South West Bicester (Kingsmere)

Application for a non-material amendment to reserved matters consent 10/00325/REM for strategic highway infrastructure: new signalised junction to the A41 serving the development at SW Bicester, "Kingsmere", and associated landscaping

Strategic highway infrastructure for a new signalised junction to the A41 was approved in March 2011 (ref 10/00325/REM). This application seeks to replace plan no. DFD/BIC/L23 Rev N approved under this consent with respect to one minor element, as referred to below.

Description		
A41 SITE ENTRANCE LANDSCAPING DETAILS		
Drawing Name	BICESTER OXFORD	Rev P
Dwg number	DFD/BIC/L23	
Drawn by	DAVID FOUNTAIN	Date
Scale(s)	1:200@AO

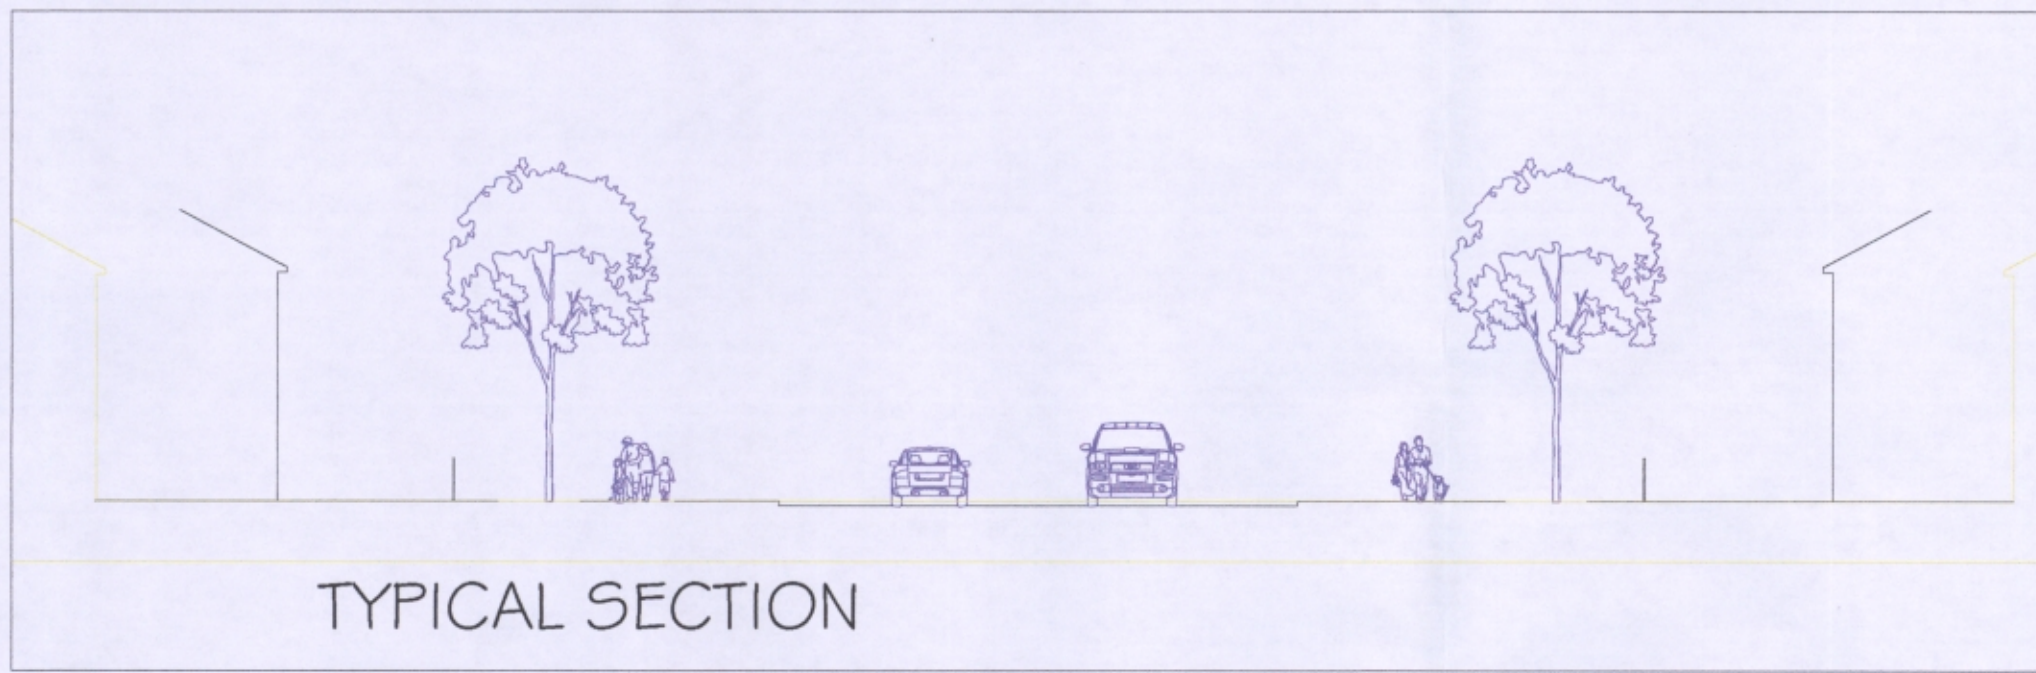
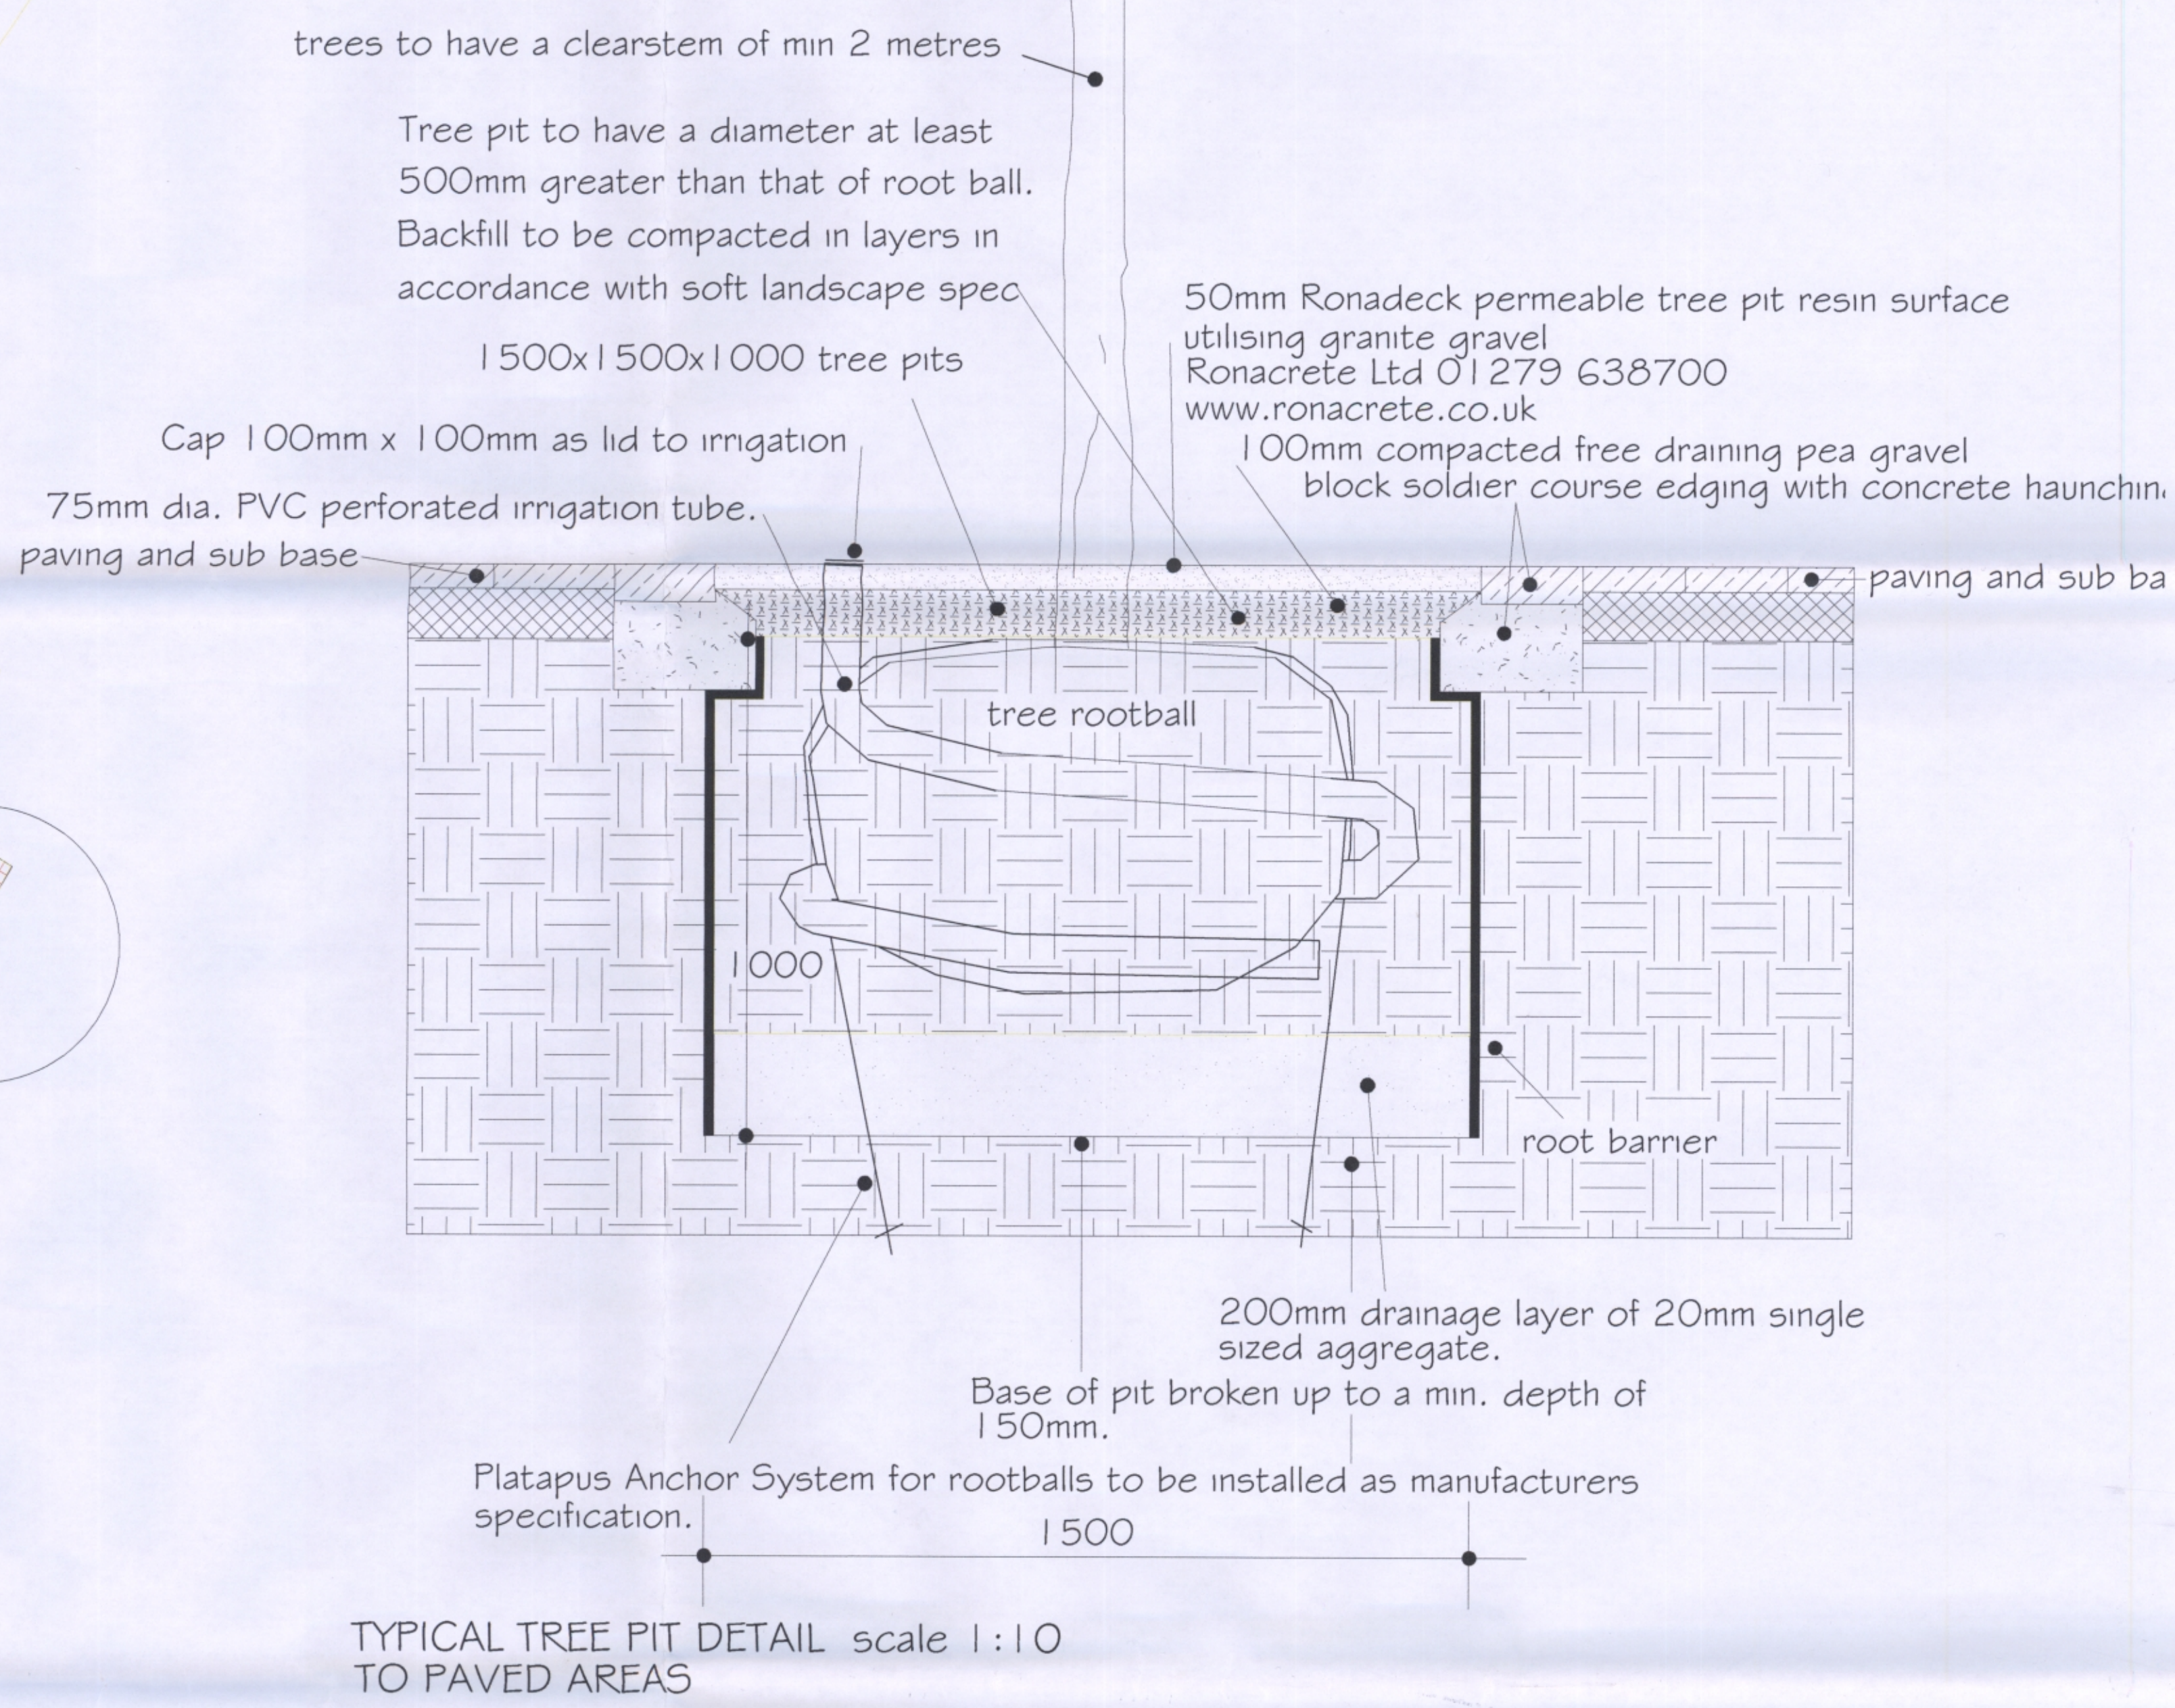
The approved plan specifies resin gravel pits for trees located at the A41 entrance; the tree pits were implemented as per the approved plan. Since implementation, surface water has not drained as efficiently as expected and has subsequently resulted in the need to remove and replace the trees due to flooding.

TYPICAL TREE PIT DETAIL TO PAVED AREAS
1:25@A1

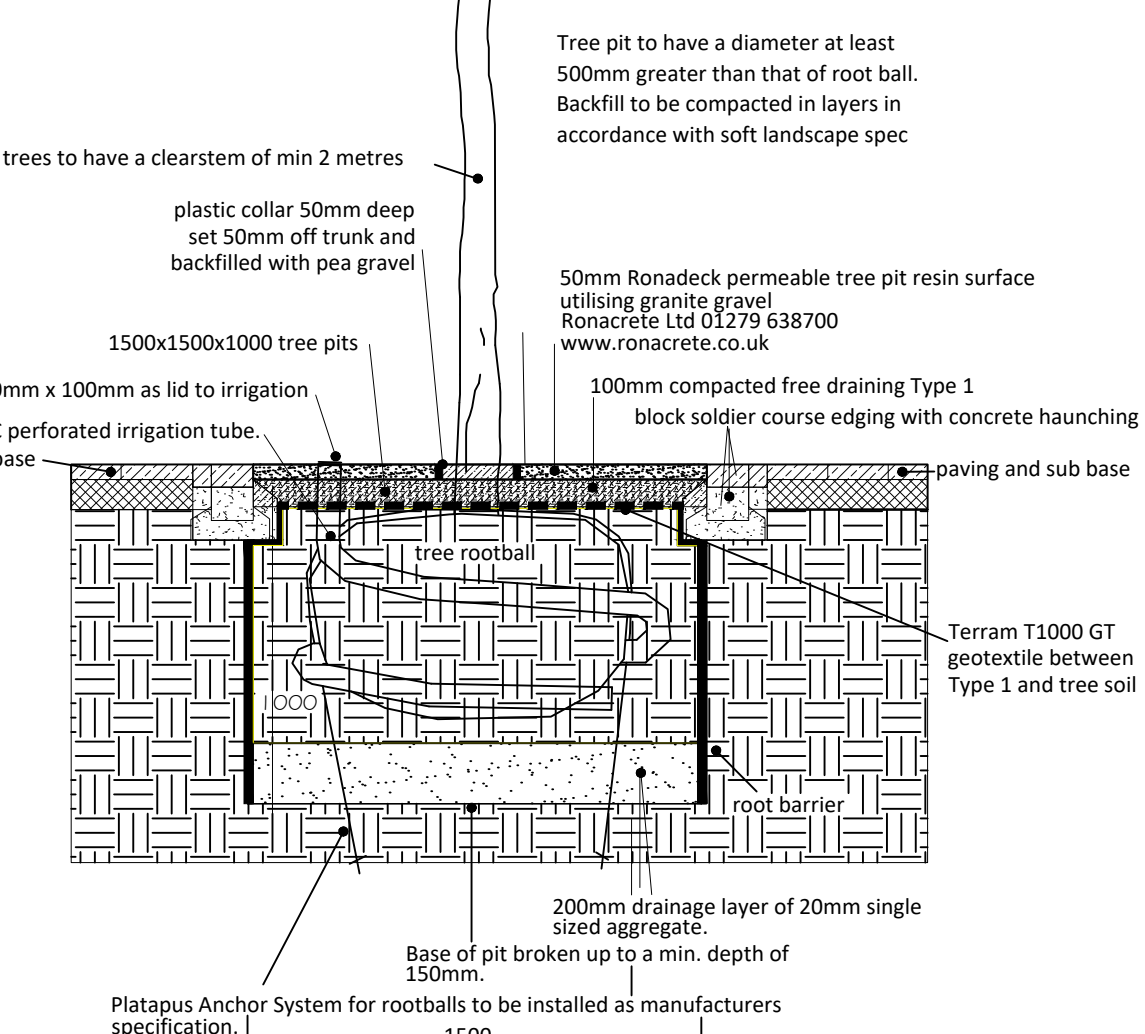
Non-material amendment application 16/00024/NMA was refused on 18 April 2016 for the replacement of the tree pits with tree grilles. Tree grilles were considered to be more costly, not eco-friendly and to not provide adequate general water catchment and gas permeability. It was also considered that tree grilles tend to attract litter and are difficult to maintain. In light of this, this submission seeks to install new resin and plastic collar tree pits.

- Application form
- Drawing no. 2226_034 Landscape proposals SL21 - revised tree pit details, 1:500 @ A1.
